AB/39/21/DOC

19 Maltravers Street Arundel BN18 9AP

Approval of details reserved by condition imposed under ref AB/125/20/L relating to Condition Nos 3 - details of junction between elevation of extension & flat roof including materials, 4 - materials & finishes for brick & brick bond, 5 - details of new external door including materials, finish & method of glazing, 6 - materials & finishes for rooflight and 7 - details of internal window including proposed glazing

Section A-A

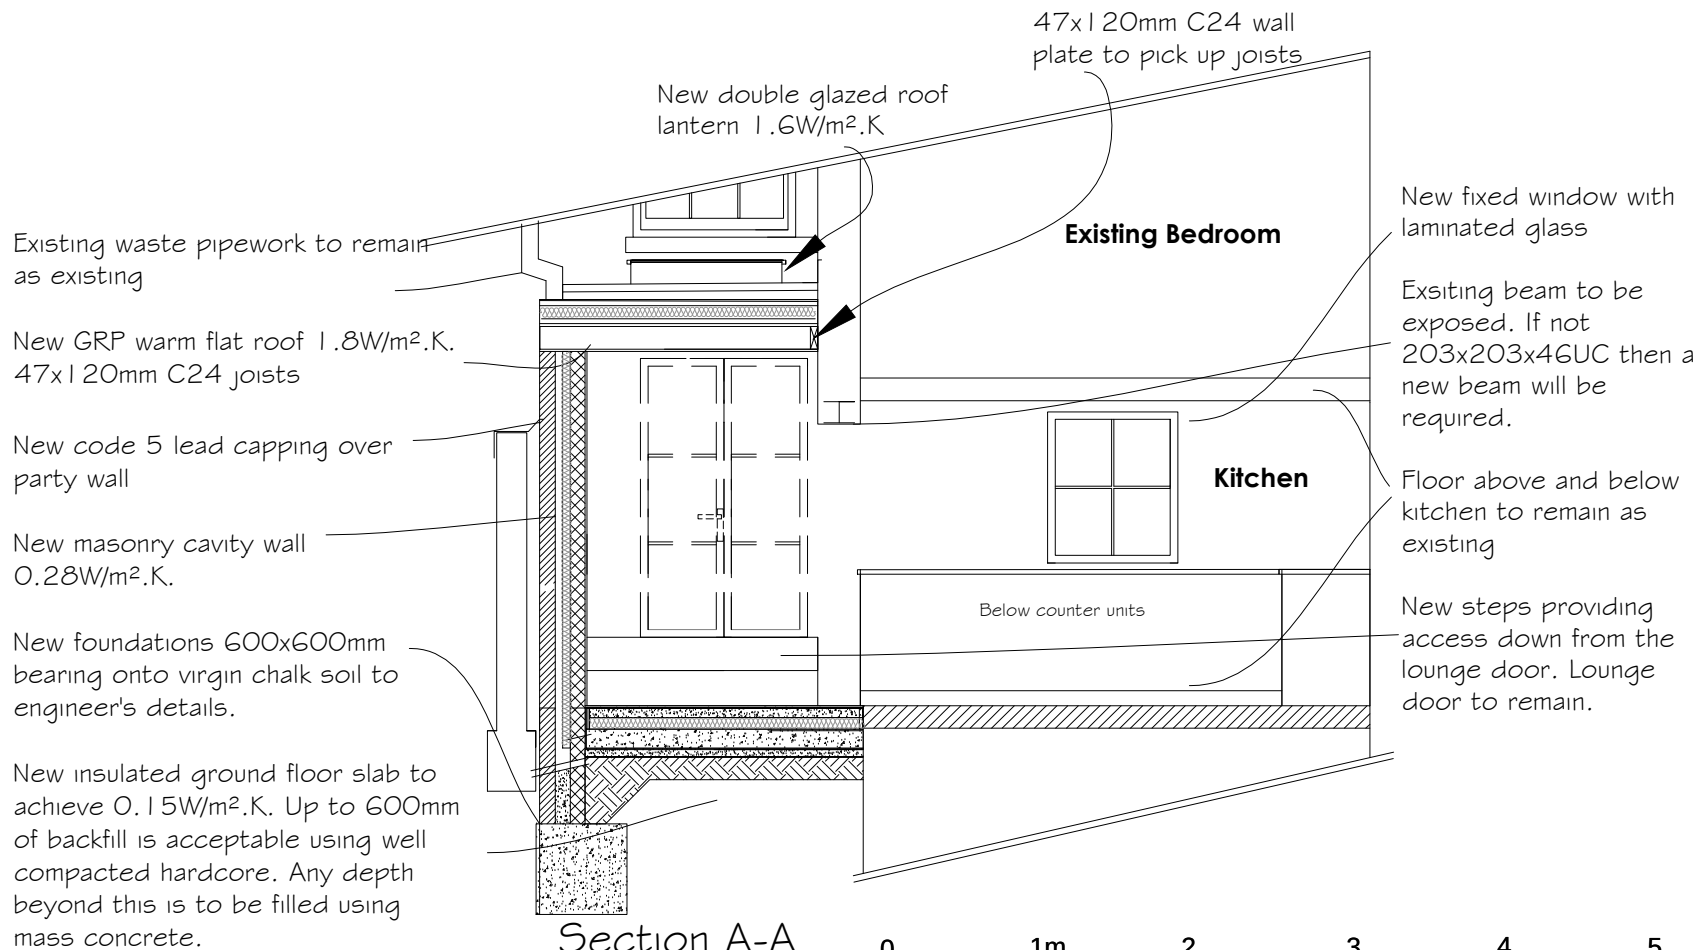
- It would help to have further information regarding the interior window: what will the glazing bars look like? Will they be integral or applied to the frame?
- I note that the intention is to revise the treatment of the small areas either side of the rear elevation door from brick to render and use the same paint colour as already present on the listed building. Whilst this approach seems to be acceptable, it would be different from the approved plans, and potentially require formal amendment?
